Application no: H11/0471/98

Applicant: Mr and Mrs S Watson
1 Netherfields
Holbeach
Spalding
Lincolnshire. PE2 7NP
Description: 3 bedroom bungalow and garage.

Location: Plot A, Oldgate
St James Road
Long Sutton
Spalding

ACKNOWLEDGEMENT OF AMENDMENT

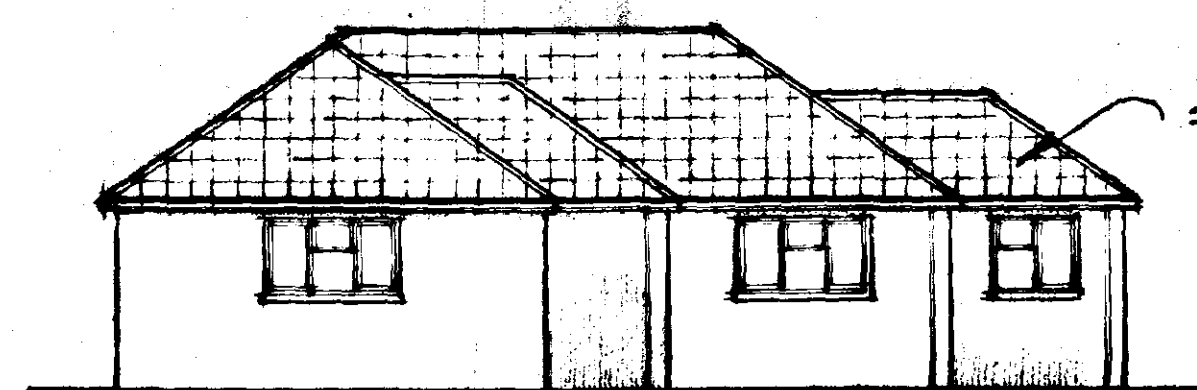
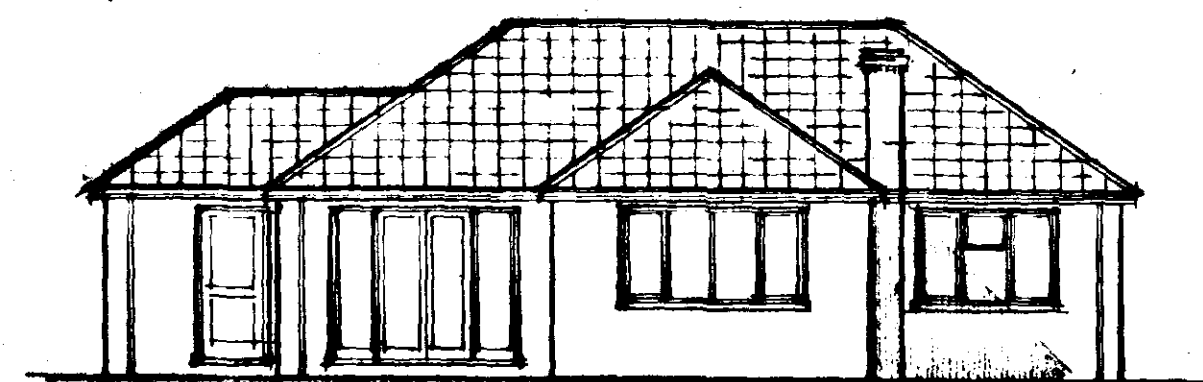
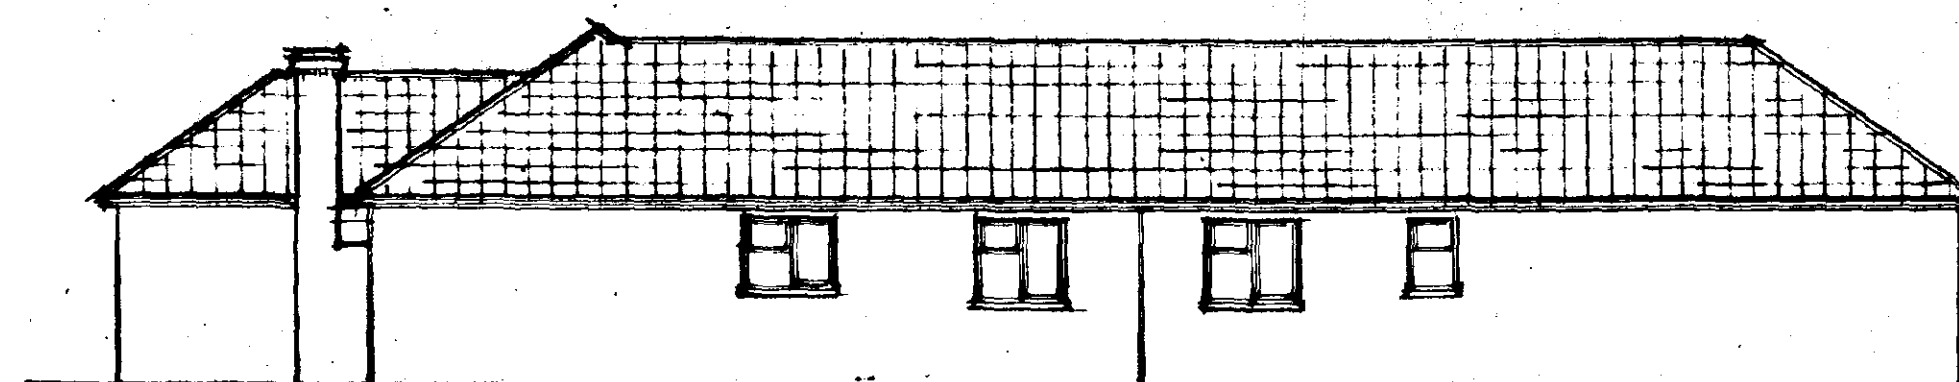
Amendment: Facing brick to be Ibstock Old Durham Stock & roof tile
to be Marley Mendip Old English Dark Red

FACING BRICK TO BE AMENDED TO
185000 OLD DURHAM STOCK

ROOF TILES TO BE AMENDED TO
MARLEY MENDIP OLD ENGLISH DARK RED
